From: Rita Williams [REDACTED]
Sent: 05 October 2017 12:30
To: Michael Eastham
Cc: Cllr. Dudley Wensley; Cllr. Andy Cooper; Cllr. Paul Bicknell; 'Administration at APC'; 'Rob Martin'
Subject: A/99/17/OUT - Land South of Water Lane (Landscape)

ANGMERING PARISH COUNCIL SUBMISSION TO PLANNING INSPECTOR MARK DAKEYNE ON ARUN DISTRICT LOCAL PLAN 2011-2031. Week 2 – 25th to 28th September 2017

Angmering North - site South of Water Lane

Plan illustrating Proposed Landscape Strategy
produced by David Jarvis, 2016. NTS.

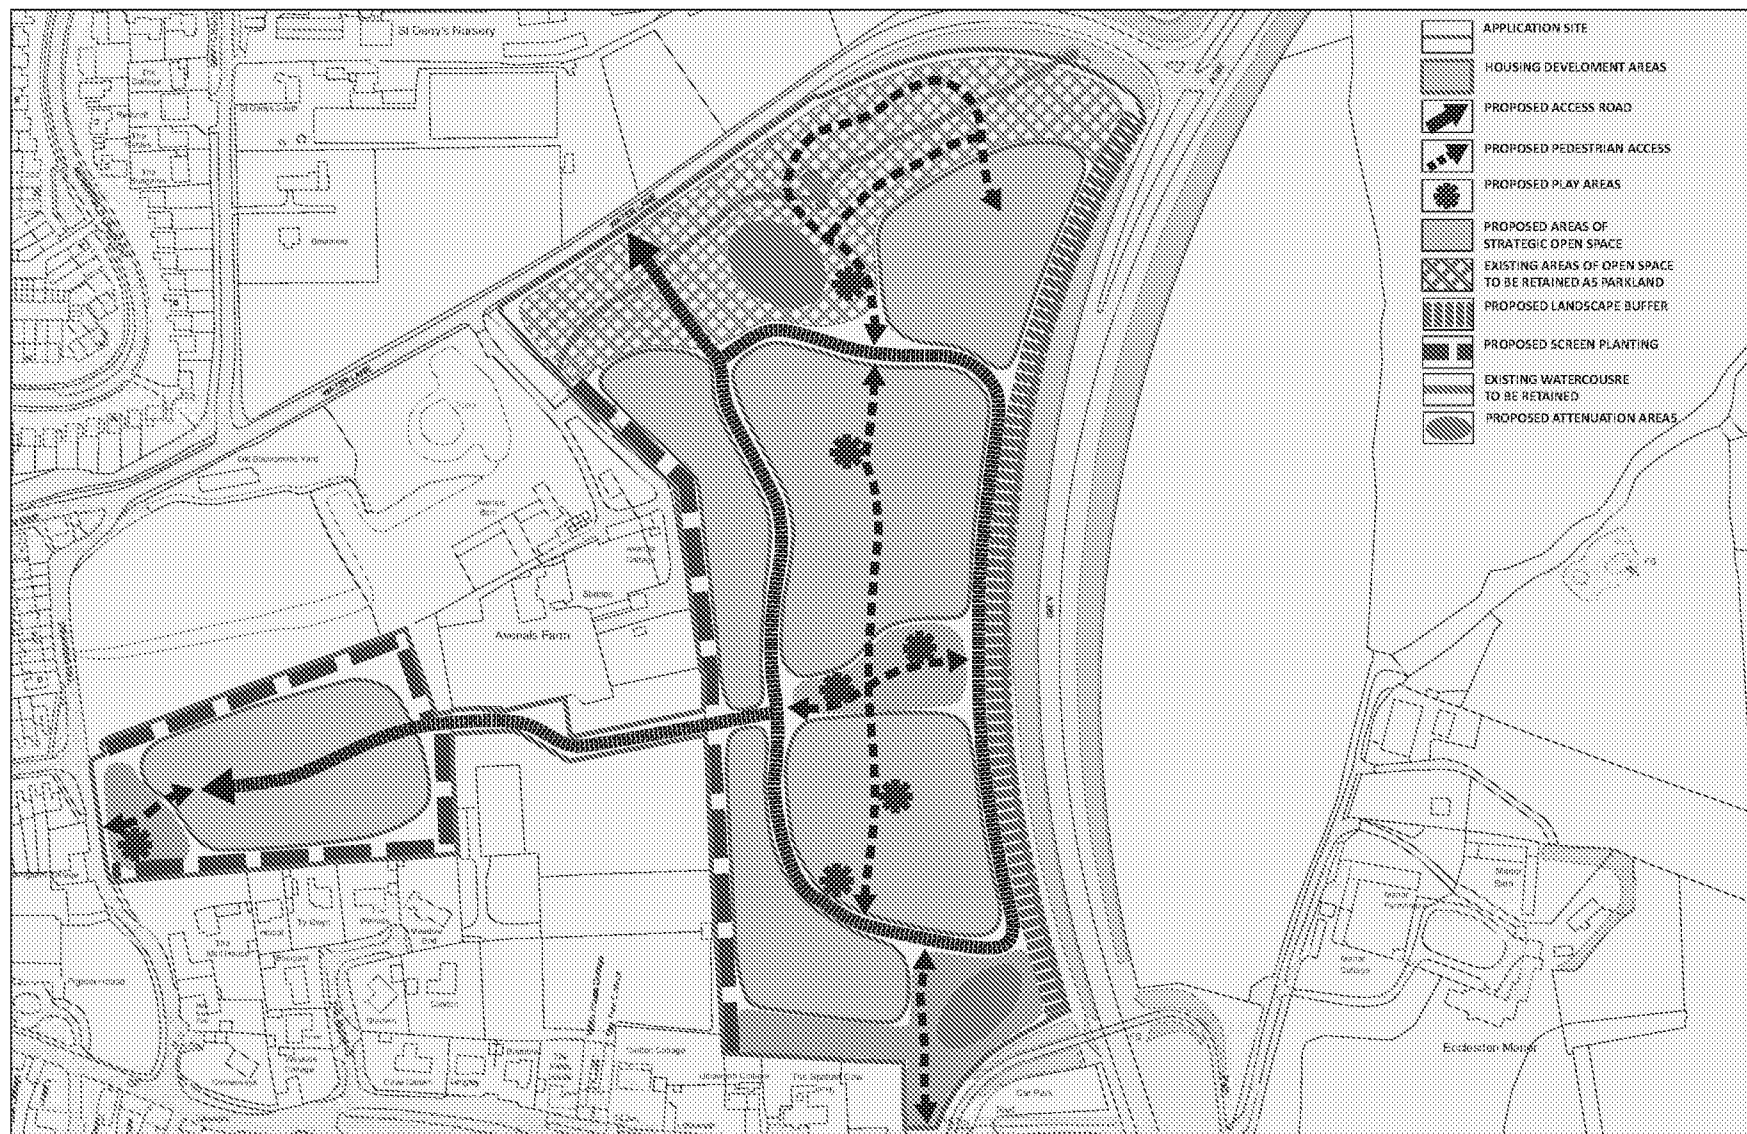
With the lack of screening from existing vegetation on the eastern boundary of the site (the gaps were left to maintain the inter-visibility with the national park) any proposed mitigation planting needs to be spelt out in more detail.
